Our Case Number: ACP-324410-26

Re: Proposed West Clare Railway Greenway Section 1: Kilrush to Kilkee Project
Kilrush to Kilkee via Moyasta, Co. Clare

Subject: Clare County Council (West Clare Railway Greenway Section 1: Kilrush to Kilkee)
Compulsory Purchase Order 2026 - Michael Shannon, Moyasta, Kilrush, Co. Clare.

Re West Clare Railway gateway
Section 1

INDICATIVE CROSS SECTION FOR SHARED ACTIVE TRAVEL ROUTE AT MOYASTA BRIDGE CAUSEWAY SCALE: AS SHOWN

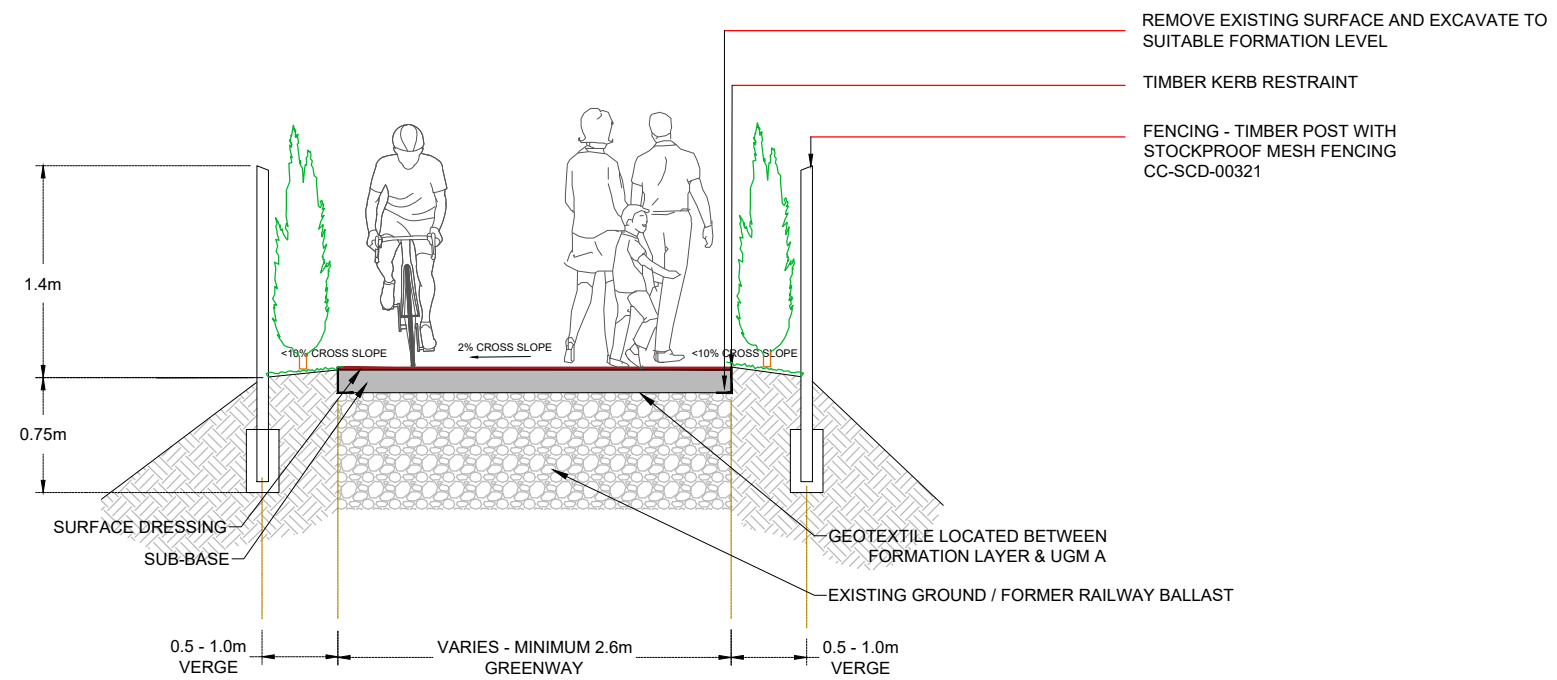
I have serious "concerns" of
the "Red Bridge" section of
the gateway that affects me.
It is my only right of way
to my lands of Folio NO4563F
Clare county council
and Rughan, O'Donoghue are
aware of this problem
for the last 5 years, and still
no workable solution has
been reached on my safe
passage over the bridge and
embankment.

The embarkment is 1.6 meters wide and farm machinery in range up to 2.55 m. The height has to go at side of greenway, nowhere to escape so the masts

will fall on ~~me~~ ^{me} and my own in the future. Lots of inconveniences. Open and close three gates on the way in and avoid greenway easers for over 300 meters and the return journey will
